DRB CASE ACTION LOG - BLUE SHEET

Project #: 1003777

Application #: 13DRB-70635

Project Name: Monarch Village

Plat of  
**Parcels 1-A and 1-B, Tract BB**  
**Monarch Village**  
 Albuquerque, Bernalillo County, New Mexico  
 July 2013

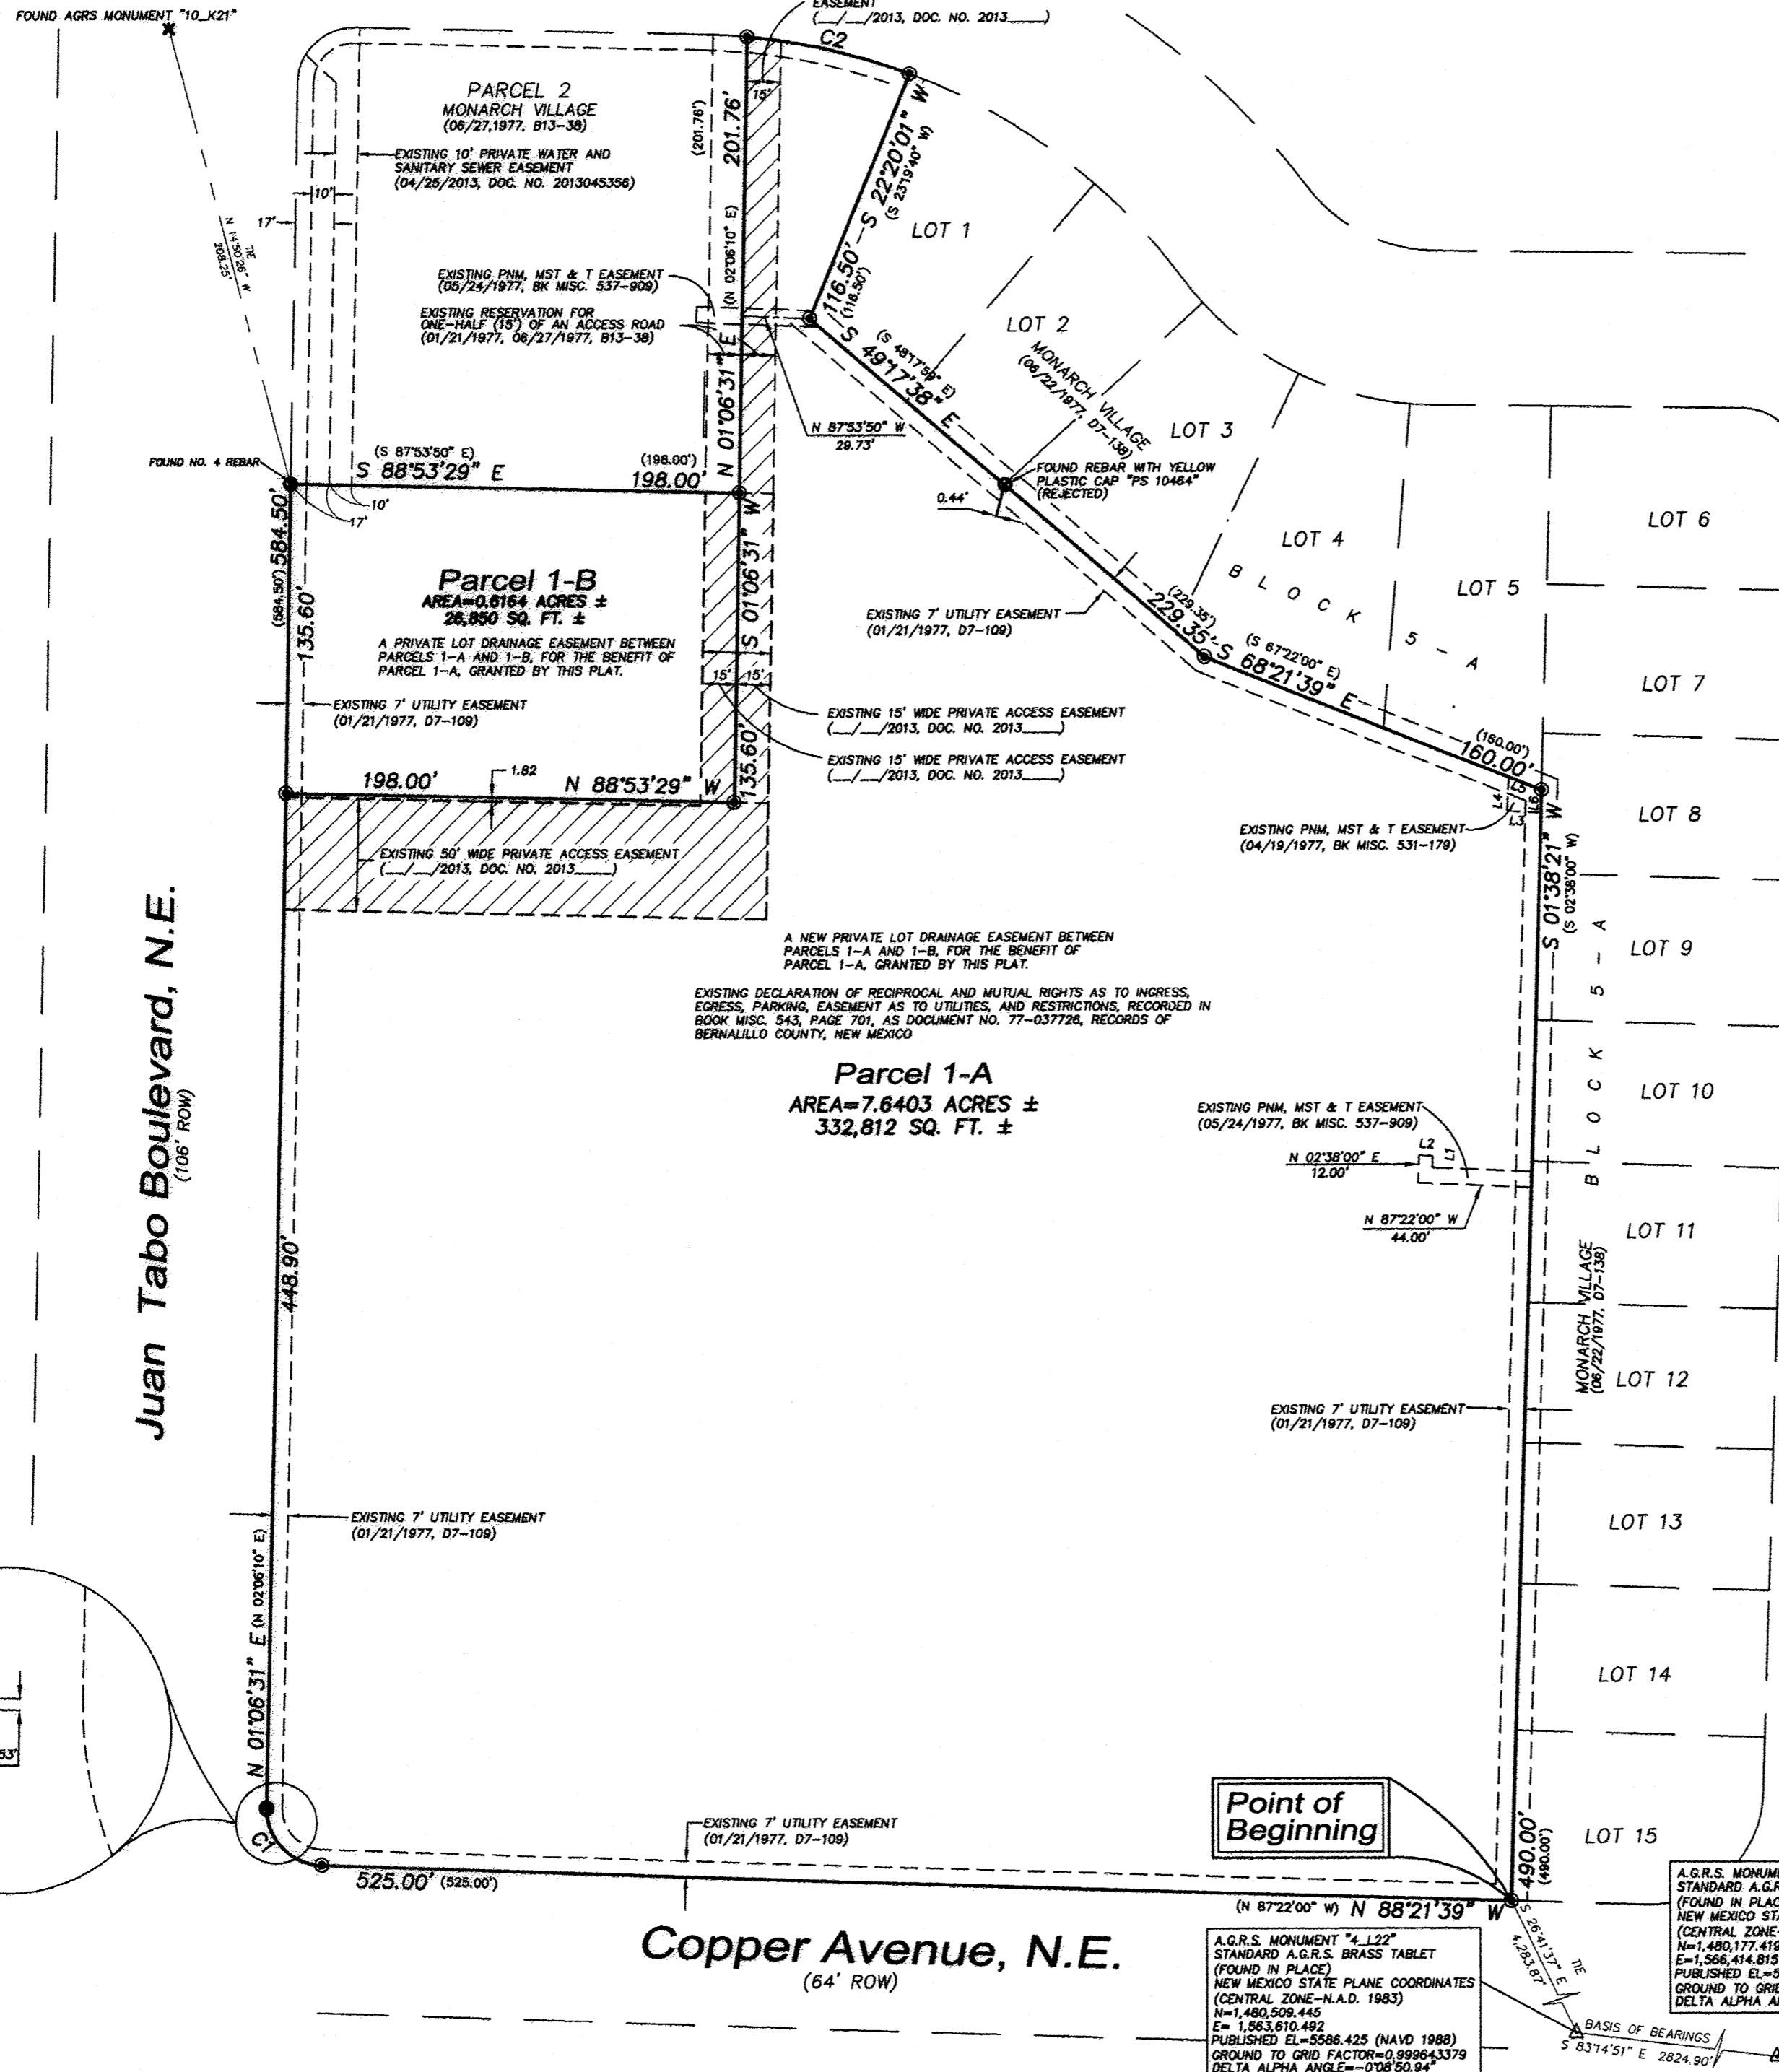
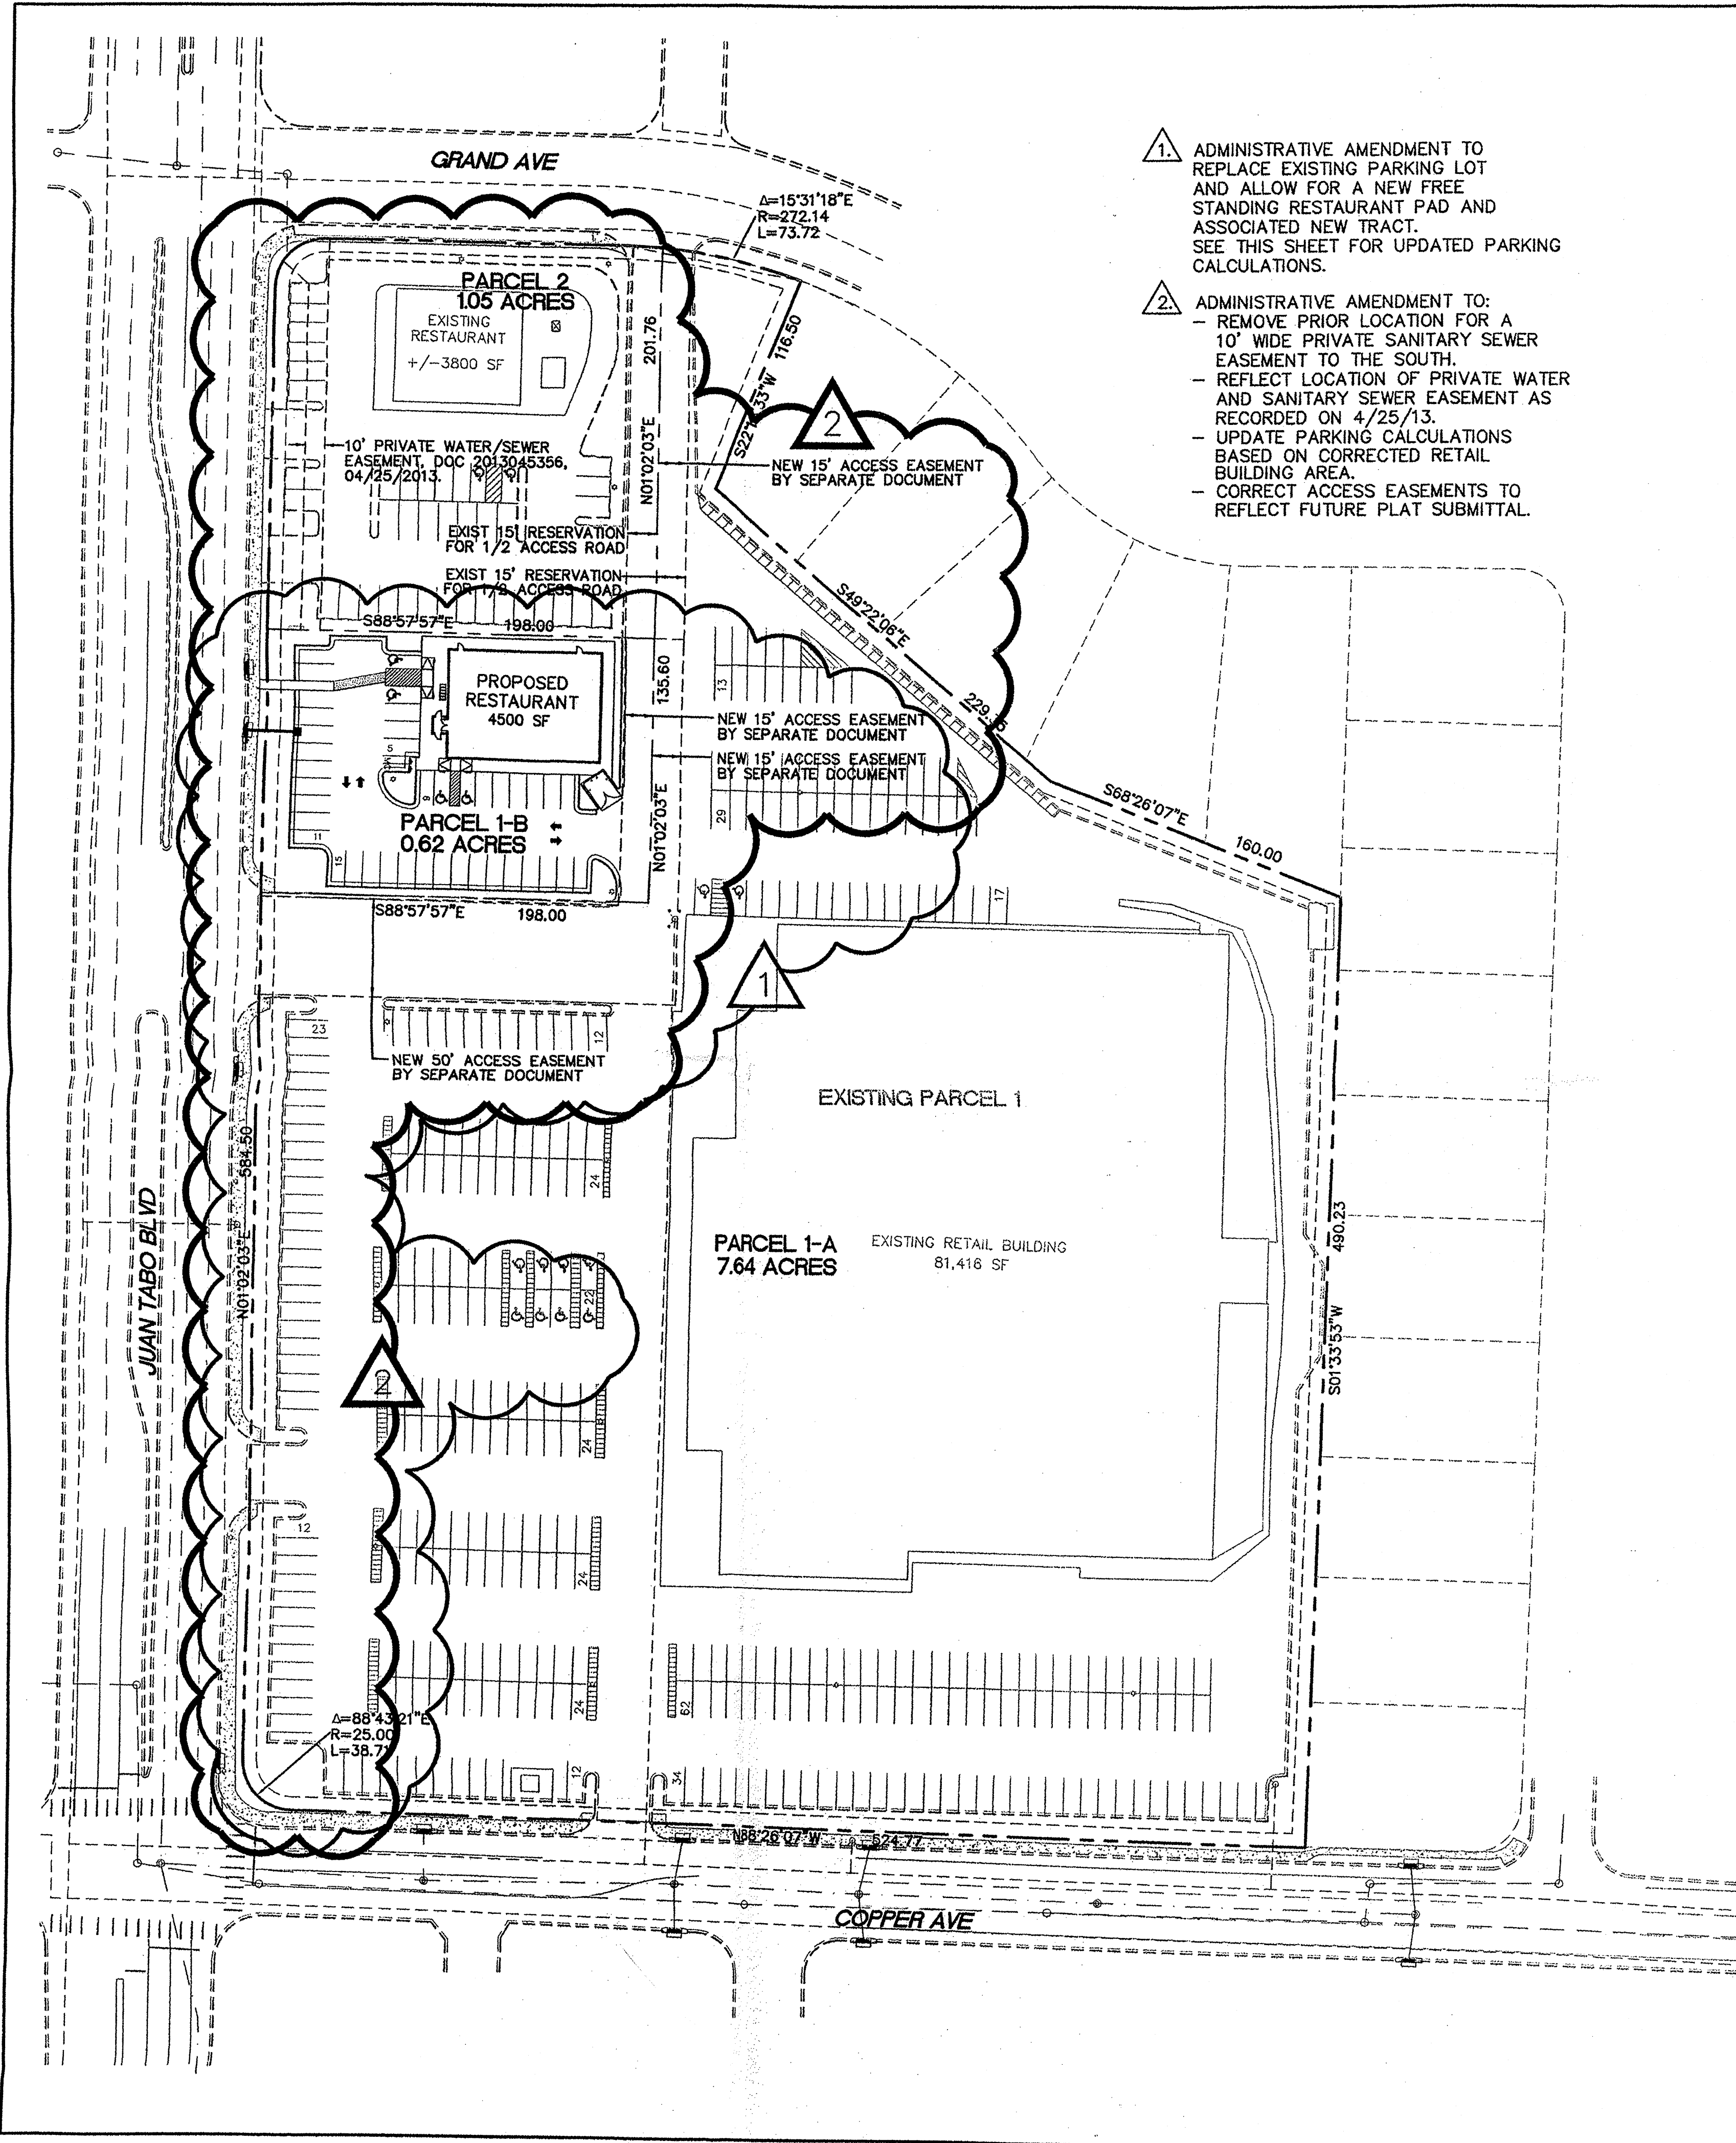
PLANNING (Last to sign): add "Cross" / ab drainage & maintenance
precise reports utility rip rap

8. **Project# 1003777**
13DRB-70635 MINOR - PRELIMINARY/
FINAL PLAT APPROVAL  TIERRA WEST, LLC agent(s) for JT PROPERTY, LLC request(s) the above action(s) for all or a portion of Lot(s) PARCEL 1 AND TR B-B, **MONARCH VILLAGE** zoned SU-1 FOR COMMERCIAL, located on JUAN TABO BETWEEN COPPER AND GRAND containing approximately 8.26 acre(s). (K-22) **THE PRELIMINARY/FINAL PLAT WAS APPROVED WITH FINAL SIGN-OFF DELEGATED TO PLANNING FOR UTILITY SIGNATURES AND THE ADDITION OF THE WORDS "CROSS" TO INDICATE CROSS LOT DRAINAGE EASEMENT.**
